DRB Application No.: 09DRB-70211 Project # 1007056
 Project Name: Heights Reservoir Addition
 Agent: Wayjohn Surveying Phone No.: _____

7. **Project# 1007056**
09DRB-70211 MINOR - PRELIMINARY/FINAL PLAT APPROVAL
- WAYJOHN SURVEYING INC agent(s) for RED ROCK CAPITAL LLC request(s) the above action(s) for all or a portion of Lot(s) 24-28, Block(s) 32, **HEIGHTS RESERVOIR ADDITION** zoned R-3, located on ADAMS ST NE BETWEEN LOMAS BLVD NE AND ROMA AVE NE containing approximately 0.7717 acre(s). (K-17) **THE PRELIMINARY/FINAL PLAT WAS APPROVED. A COPY OF THE RECORDED PLAT MUST BE PROVIDED TO PLANNING.**

**CITY OF ALBUQUERQUE
PLANNING DEPARTMENT
April 23, 2008
DRB Comments**

RE: Lots 24- 28, Heights Reservoir Addition

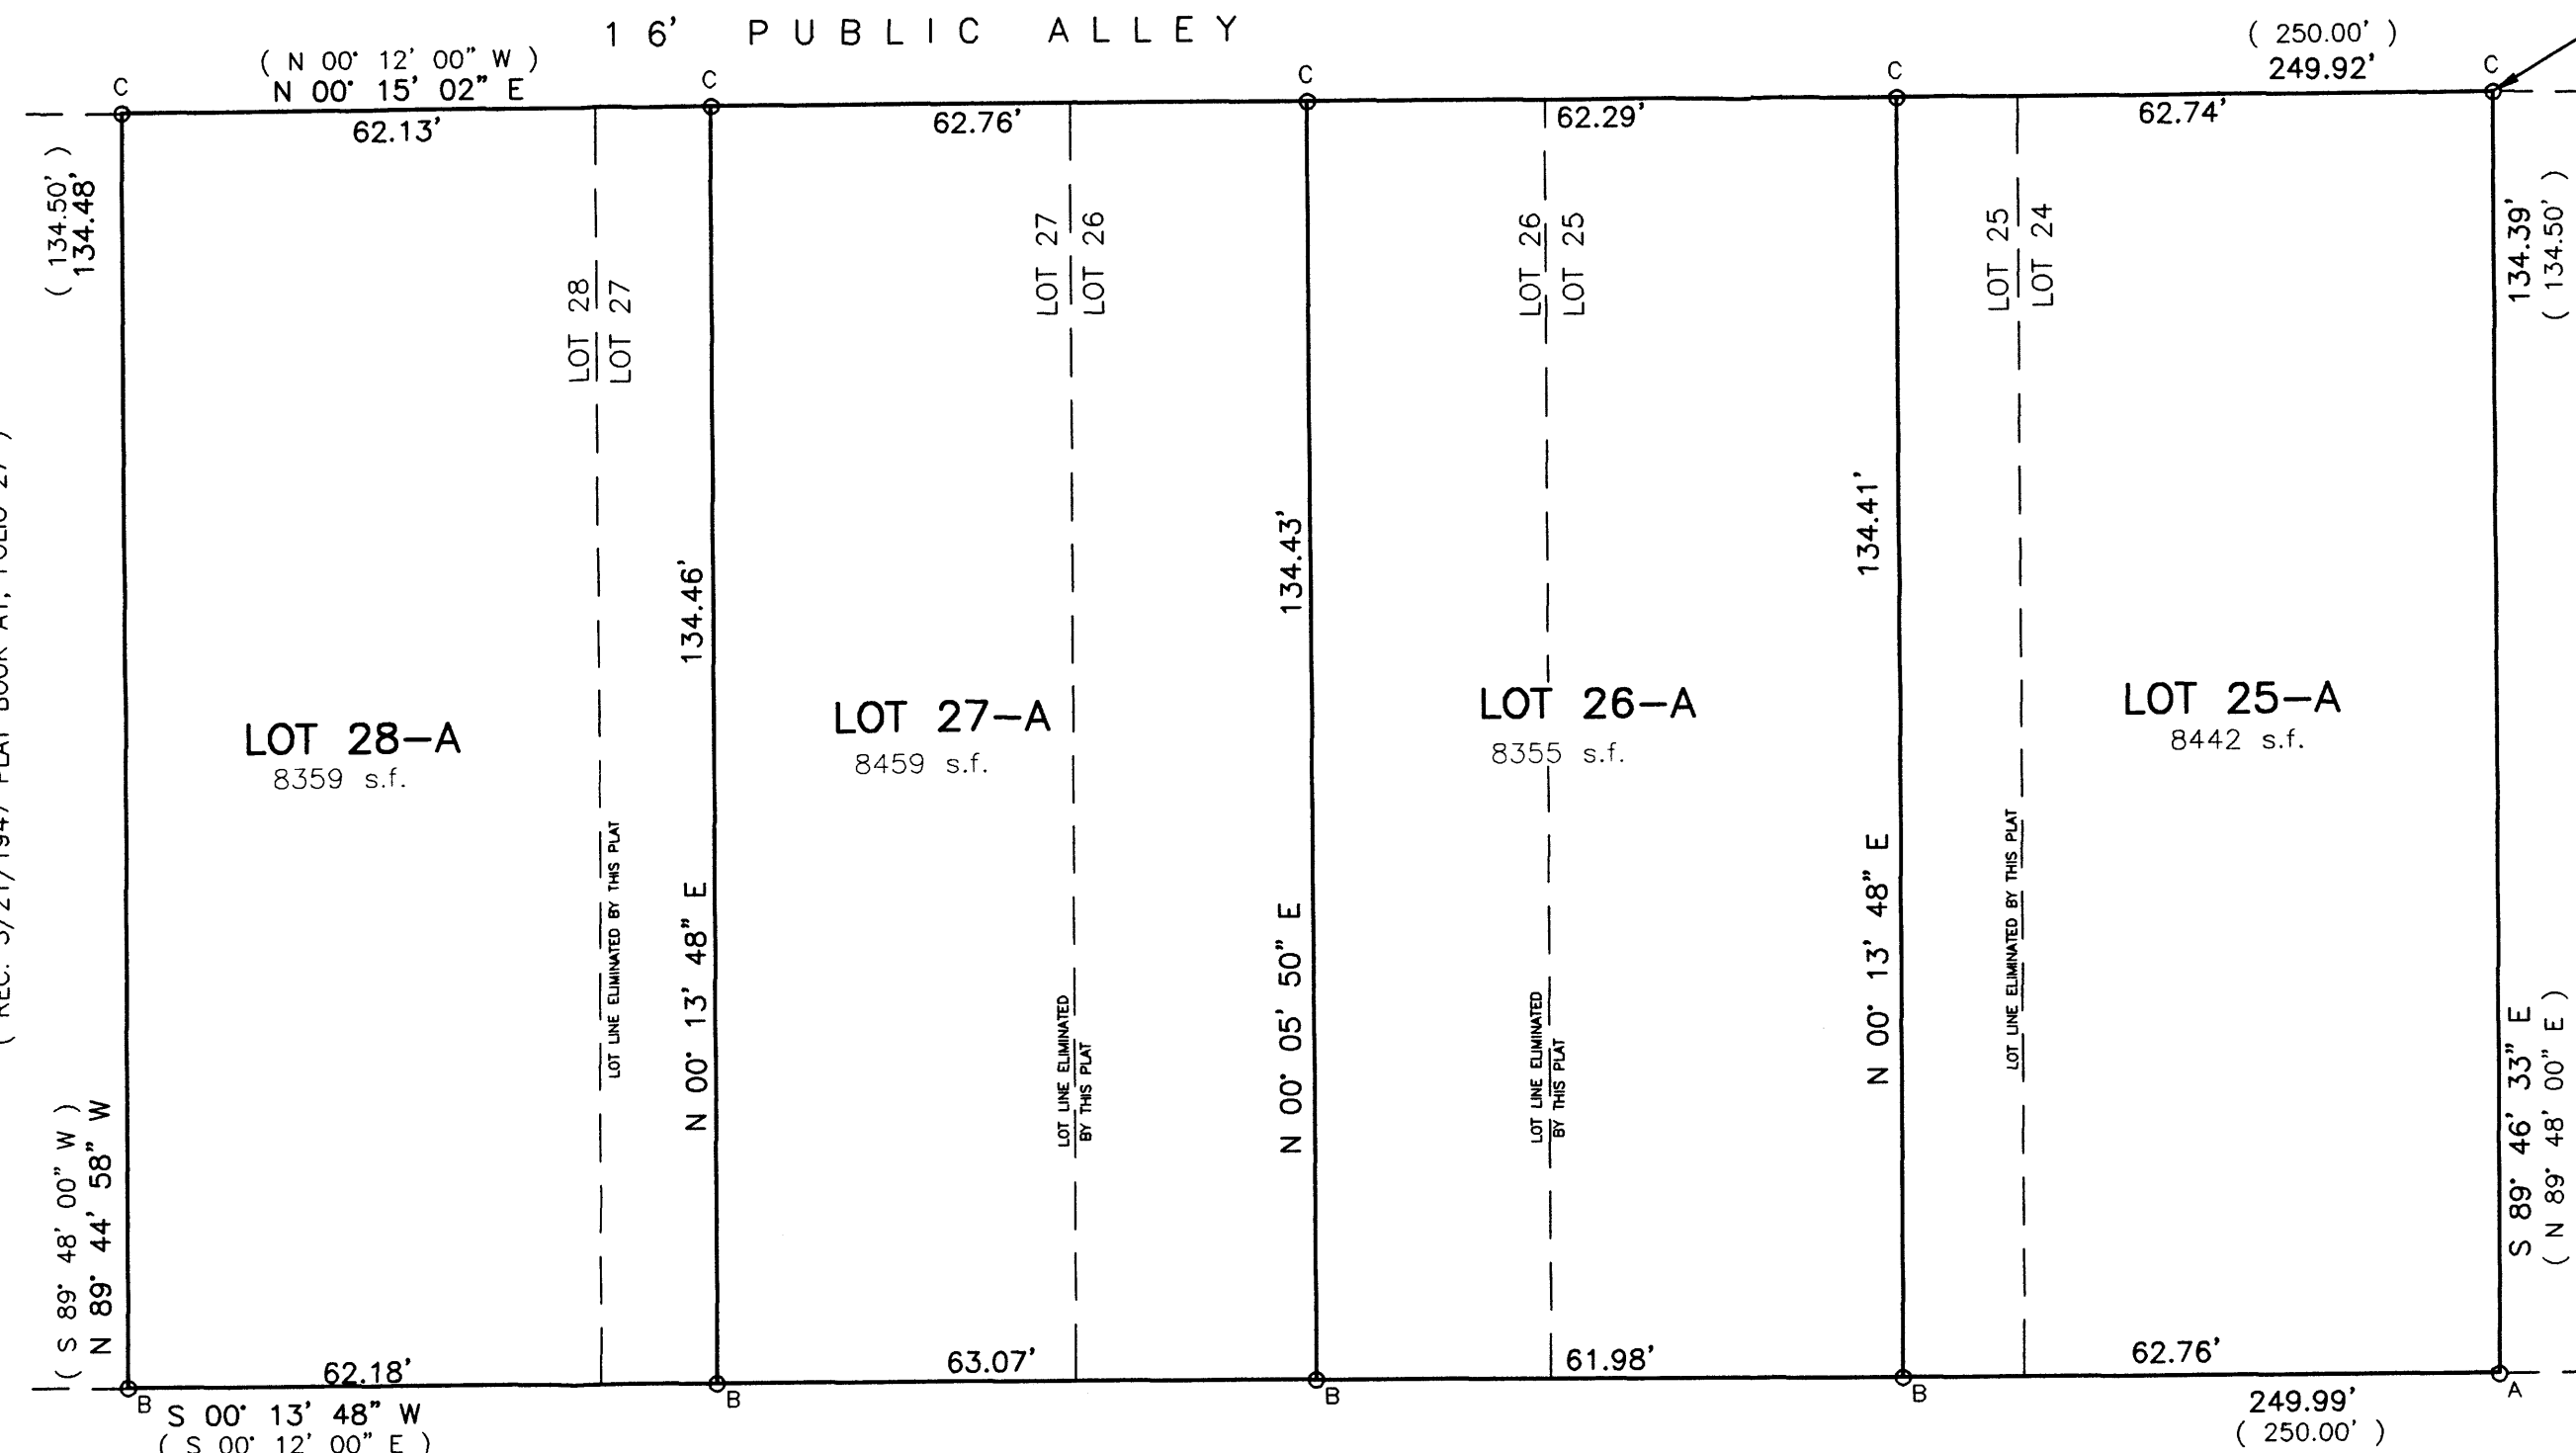
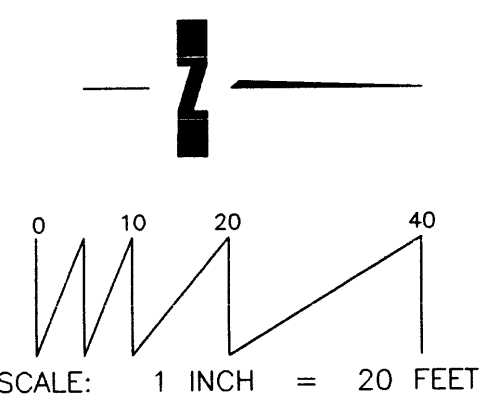
Certification will be needed to demonstrate that the existing garage buildings meet the building code in relation to the proposed lot lines.

For future reference, please do not identify the property's zoning (Note 3) on the plat.

The two projects referenced above were heard on April 23, 2008. One of the requirements of final plat approval was the verification of a one-hour fire rated wall for each of the buildings that demise on the new property line. I have inspected the site and I have found that the interior walls on the new property line meet the one-hour fire rating. Additionally, the developer has constructed new roof parapets that meet the one-hour fire rating for residential construction. Therefore, it is my professional opinion that theThe two projects referenced above were heard on April 23, 2008. One of the requirements of final plat approval was the verification of a one-hour fire rated wall for each of the buildings that demise on the new property line. I have inspected the site and I have found that the interior walls on the new property line meet the one-hour fire rating. Additionally, the developer has constructed new roof parapets that meet the one-hour fire rating for residential construction. Therefore, it is my professional opinion that the structures now meet the required one-hour fire rating for demising walls adjoining structures.
